Our Ref: R/2025/15/C  
File No: 2026/242780  
Your Ref: SSD-93222706

**Advice on EIS – Waterloo Estate (South) Concept – SSD-93222706**

Thank you for your correspondence, dated 4 May 2026, inviting the City of Sydney Council (the City) to comment on SSD-93222706 for the concept approval for the staged redevelopment of Waterloo Estate (South), supported by a concurrent rezoning to modify Sydney Local Environmental Plan 2012 (SLEP 2012) and the Waterloo Estate (South) Design Guide (Design Guide).

Drawing Name
Block 10
Proposed Envelope -
Plan

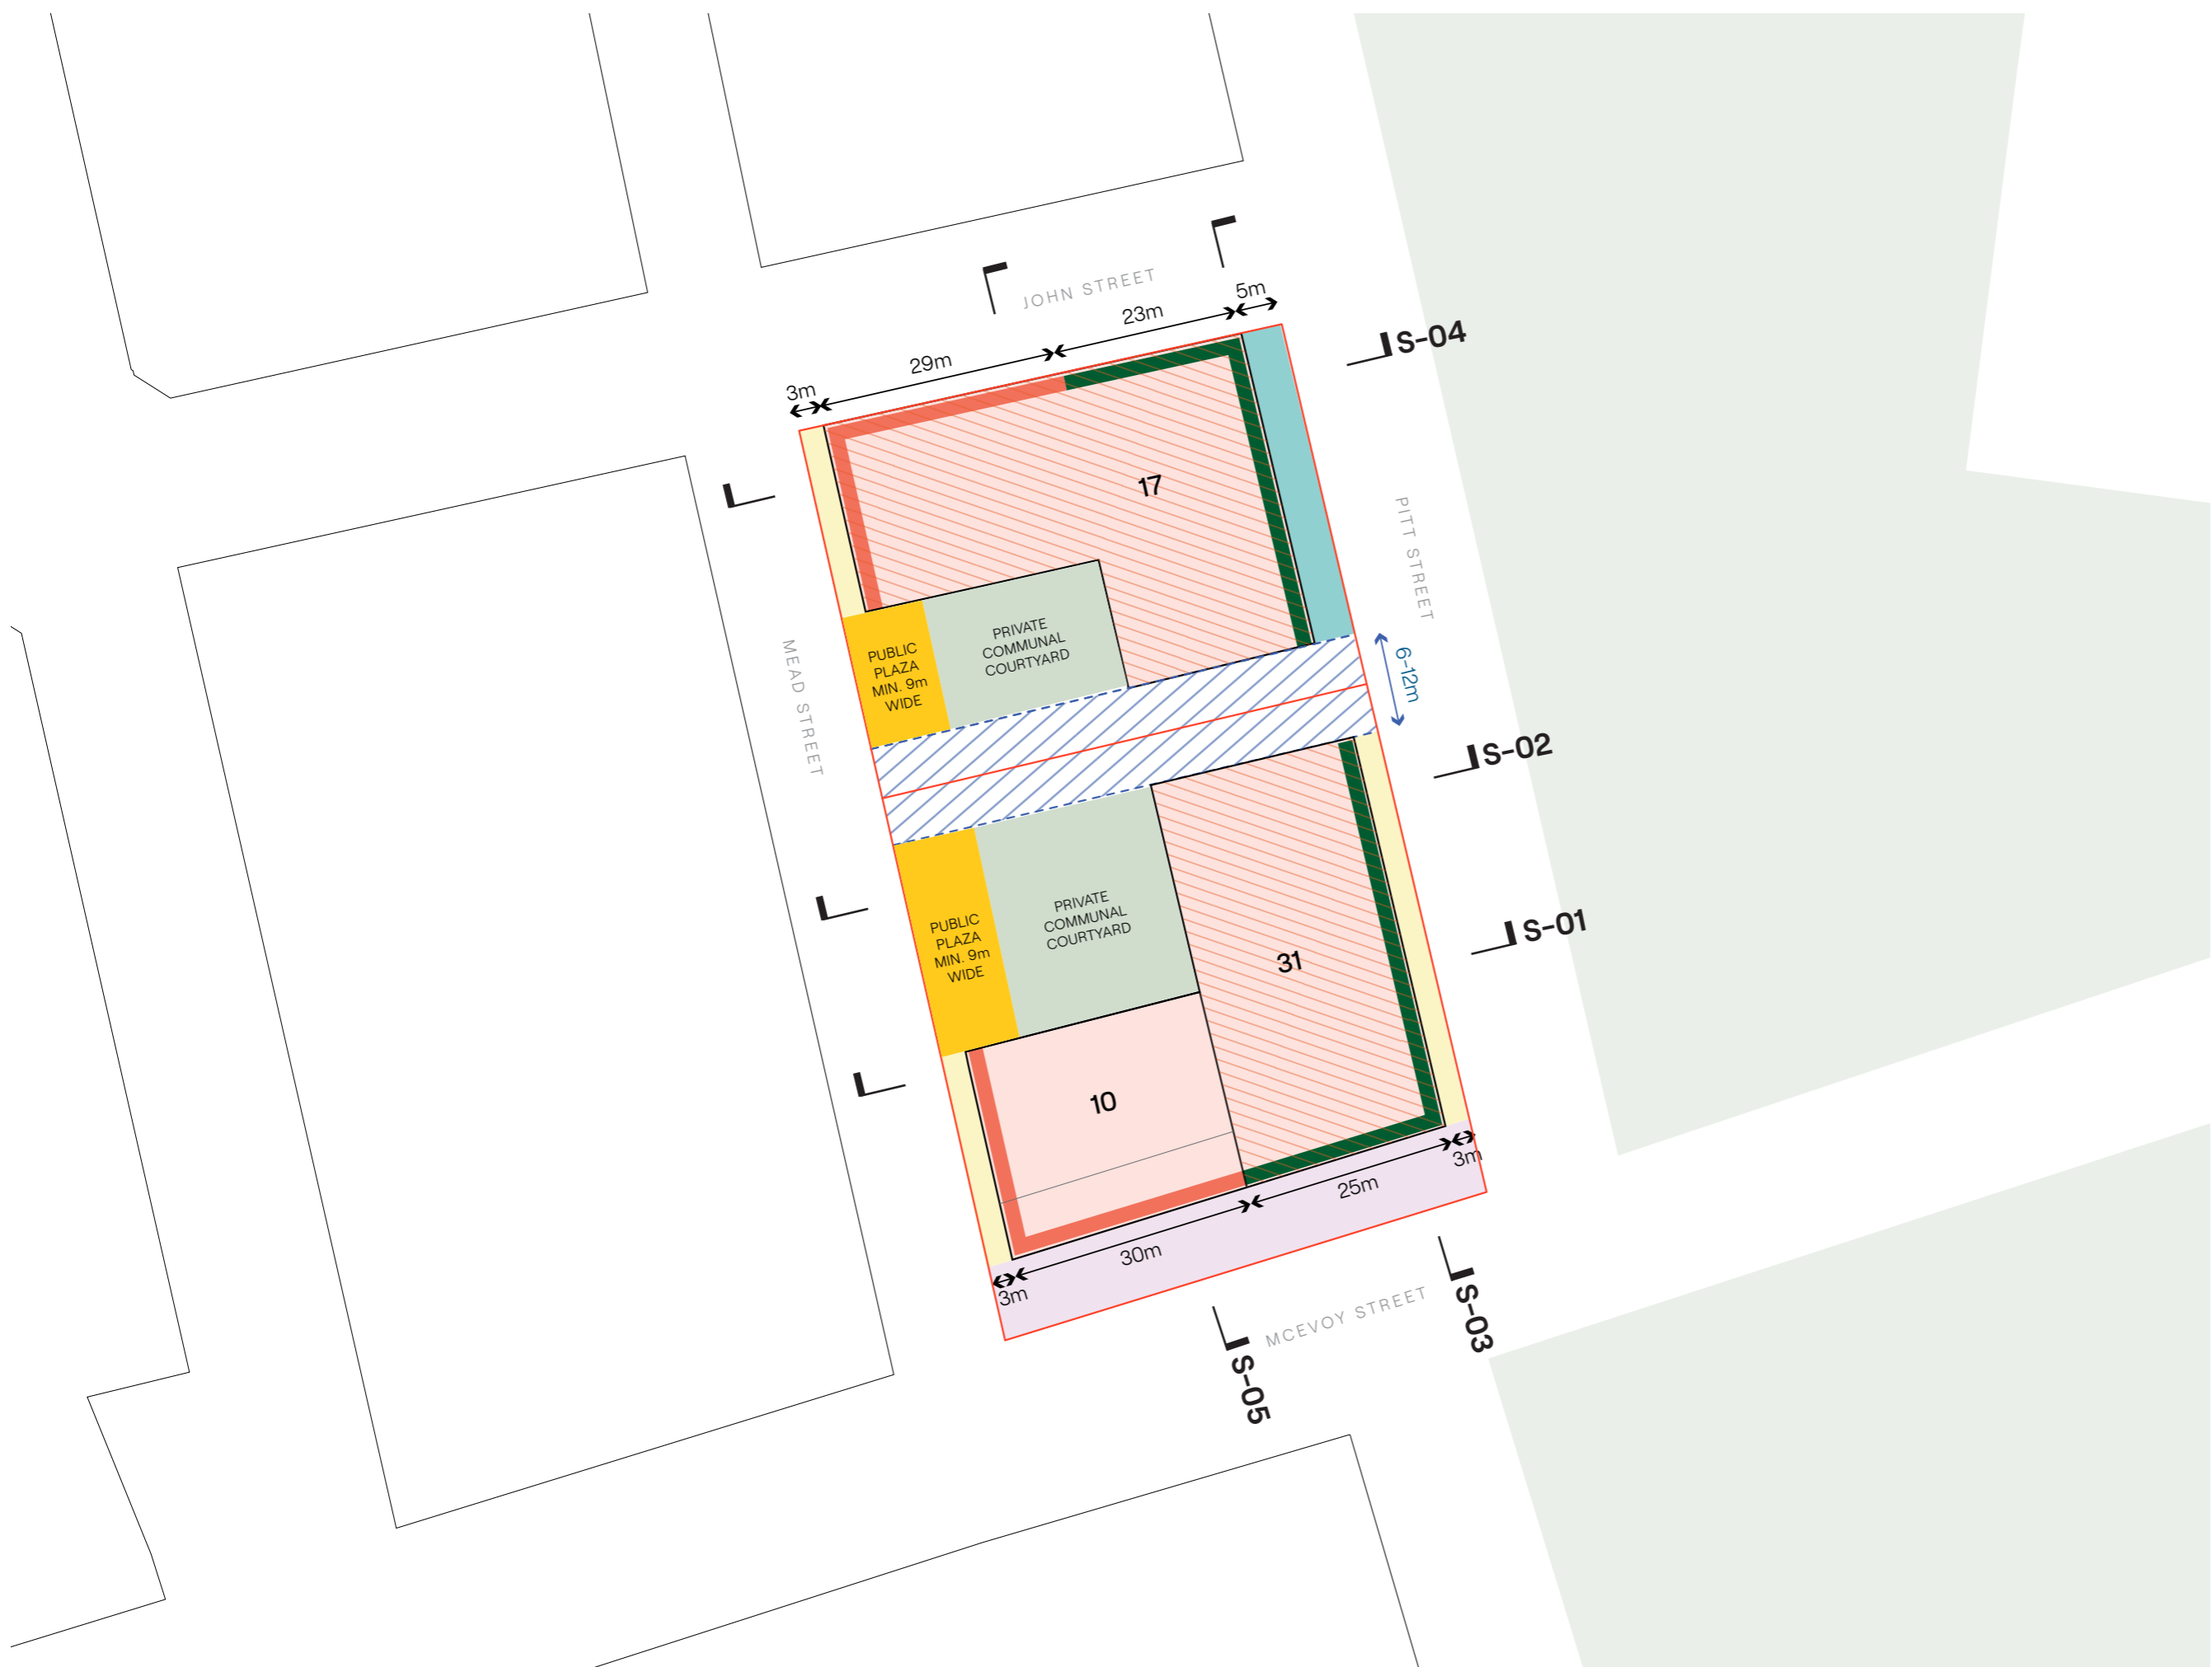
| Block | Proposed LEP height control | Reference scheme height | Recommendation                                                                                                                                                           |
|-------|-----------------------------|-------------------------|--------------------------------------------------------------------------------------------------------------------------------------------------------------------------|
| 10A   | 39m                         | 35m                     | LEP height is too high and should be reduced by 4m                                                                                                                       |
